Re: 34 Bay Street – 156 B014 – R-3 – new single family home – permit #10-0196

I have reviewed the permit application to build a new single family home at 34 Bay Street. At this point I must deny the permit.

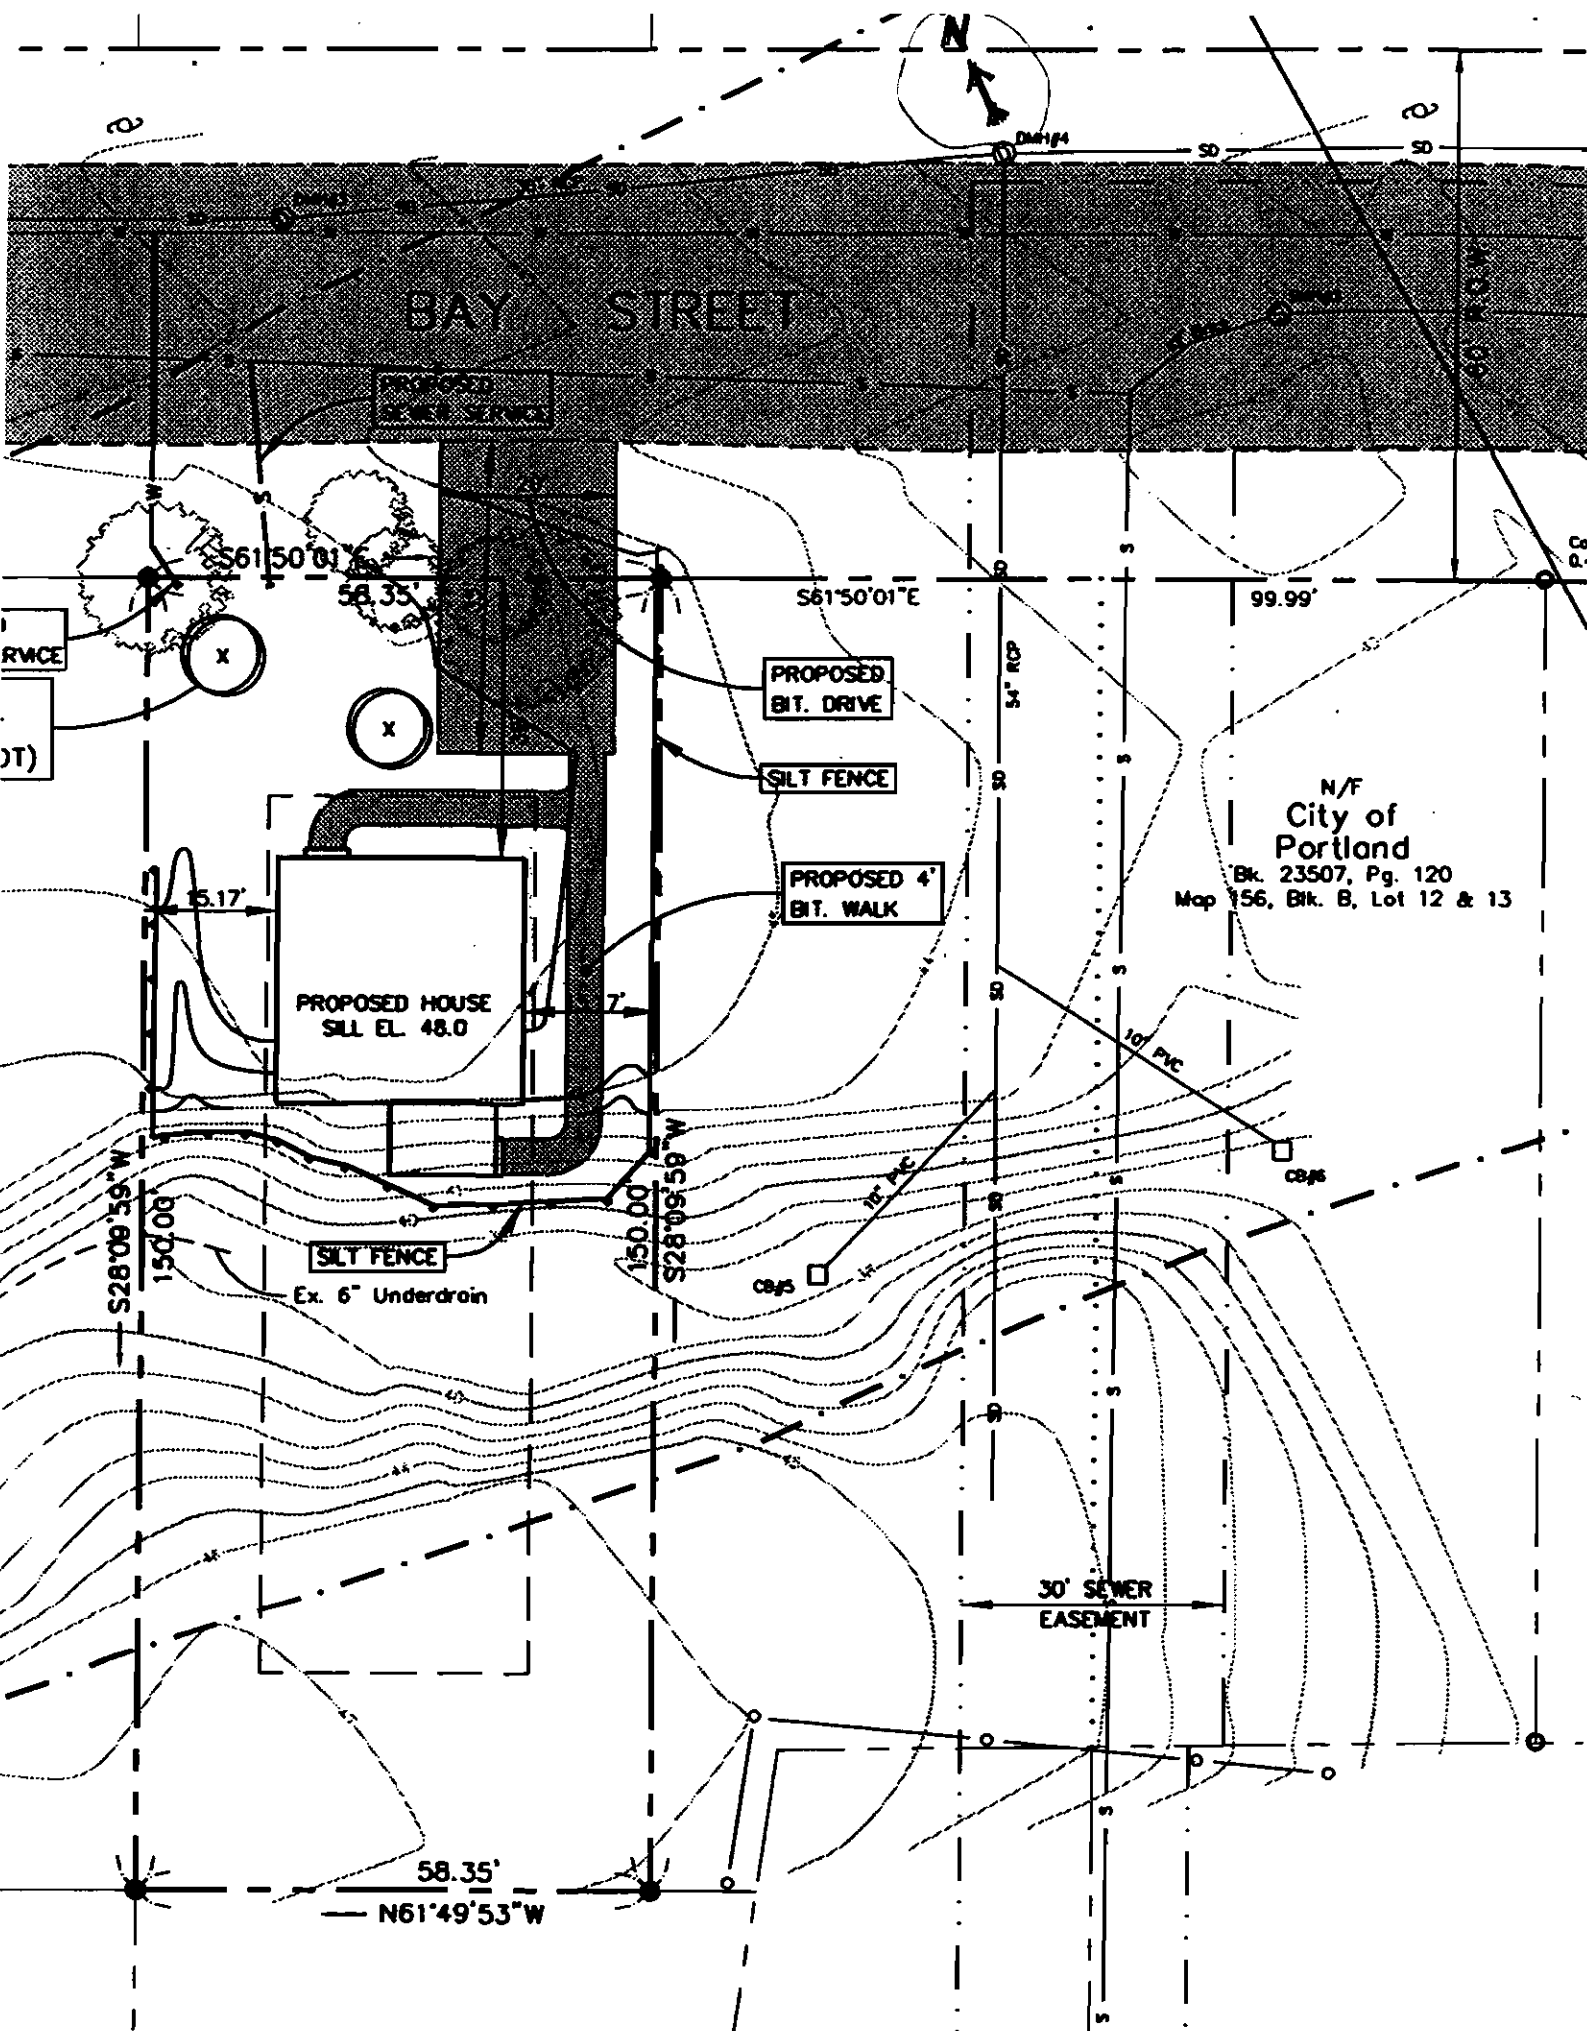
34 Bay Street is located in the R-3 residential zone. The required minimum lot width is sixty-five (65) feet [section 14-90(f)]. In other words, the lot needs to be a minimum of sixty-five feet wide where the house is located on the lot (section 14-47). The siteplan shows the lot to be 58.35' wide at the building, so the required minimum lot width is not being met.

The parking requirement is also not being met. Section 14-332(a)(1) states that for construction of a new residential unit, two off street parking spaces are required. According to section 14-336(a), the parking spaces cannot be located in the required front yard setback and they cannot be located within five feet of the side setback for the first fifty feet back from the street line. Right now the two parking spaces shown on the siteplan are within the twenty-five foot front yard setback.
